# **SCOPING OPINION:**

## Proposed Helios Renewable Energy Project

**Case Reference: EN010140**

**14 July 2022**

Environmental Statement Figure 6.1: Heritage Assets Considered within the ES

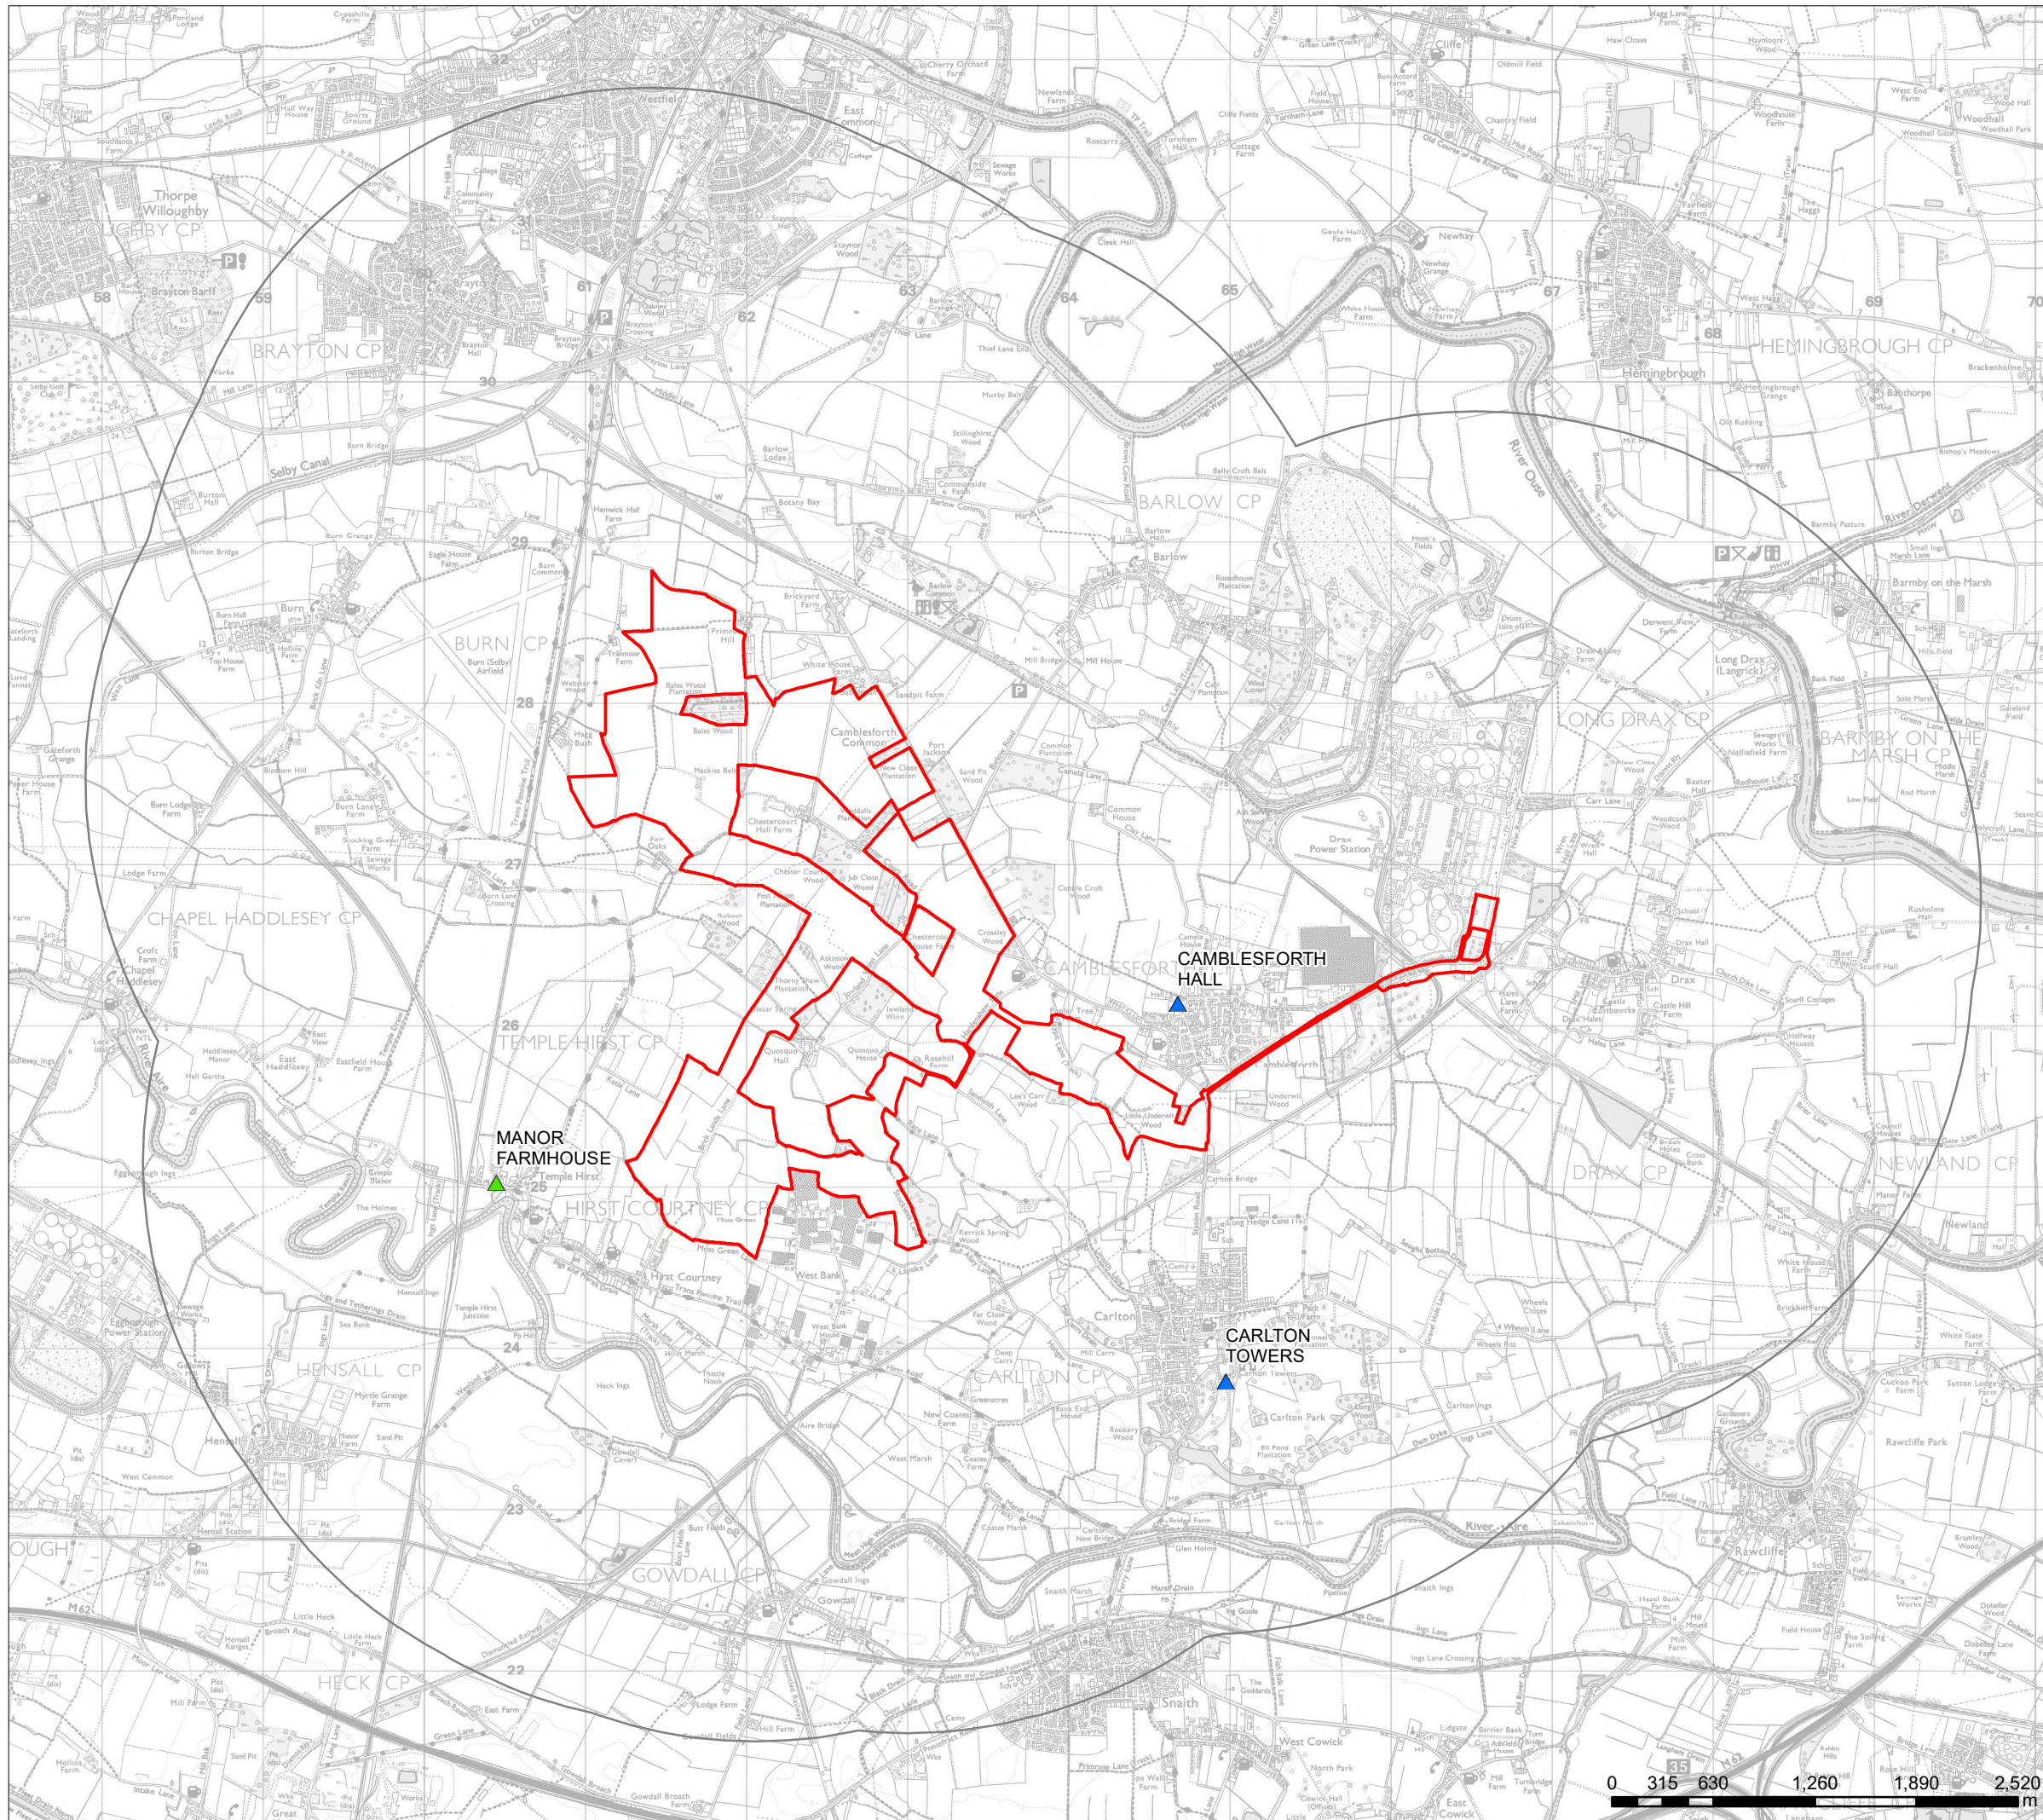
3.2.4	Table 6.1	Effects on Listed Buildings within the study area, excluding Grade I Listed Camblesforth Hall and Carlton Towers and Grade II listed Manor Farmhouse	<p>The Inspectorate does not agree to scope out impacts to listed buildings as some are located within the worst-case 3km study area (Figure 6.2) and no justification is provided for scoping them out.</p> <p>The ES should assess both direct and indirect impacts to listed buildings where significant effects are likely to occur.</p>

**Environmental Statement Figure 7.15.1:
Cumulative ZTV, Proposed Development
and Drax Bioenergy with Carbon Capture
and Storage – Bare Earth**

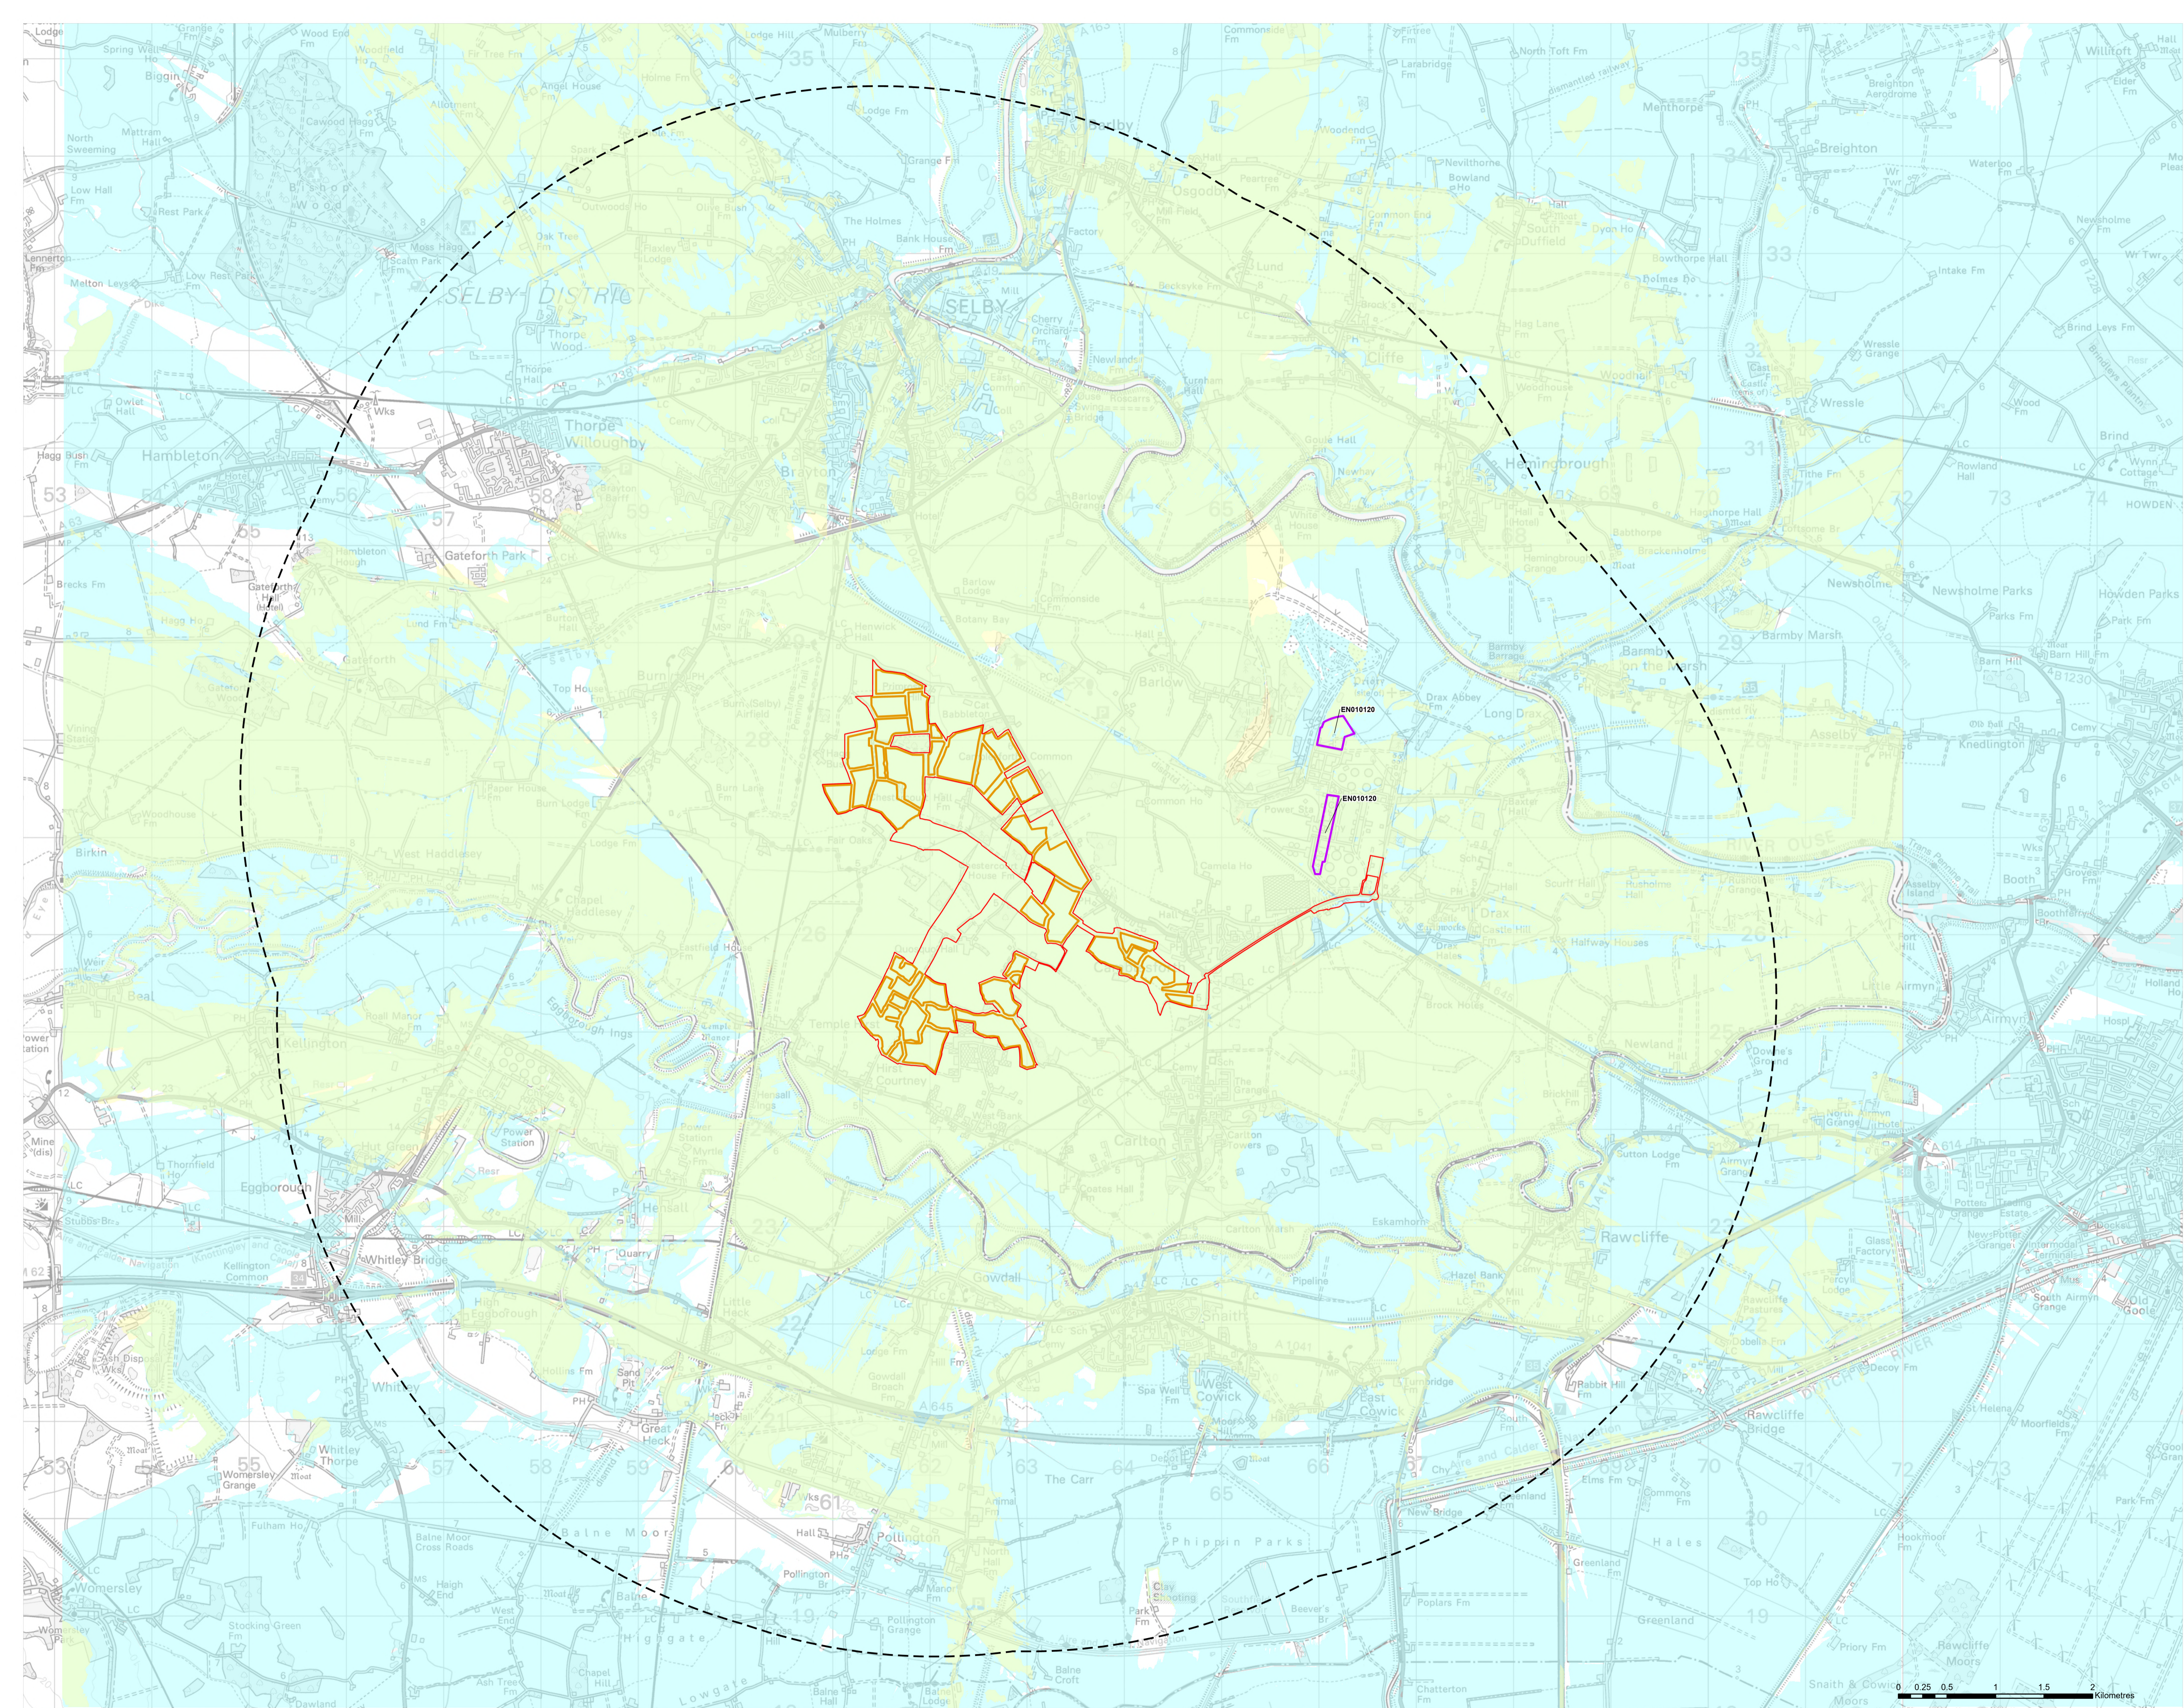
ID	Ref	Description	Inspectorate's comments
3.3.2	7.2.1 and Figures 7.1 and 7.2	Preliminary ZTV/study area	<p>The full extent of the preliminary ZTV and subsequent study area is not defined in the Landscape and Views Chapter whereas it is defined in the Cultural Heritage Chapter. Figures 7.1 and 7.2 depict the ZTV however, potential visibility of the site overlaps the edges of the map therefore its full extent is unknown. Additionally, the Scoping Report does not establish the tallest elements of the Proposed Development that influence the ZTV (please see box 2.1.1 above).</p> <p>The ES should ensure that the final extent of the ZTV reflects the maximum parameters of the Proposed Development where relevant. Effort should be made to agree appropriate ZTVs with relevant consultation bodies.</p>
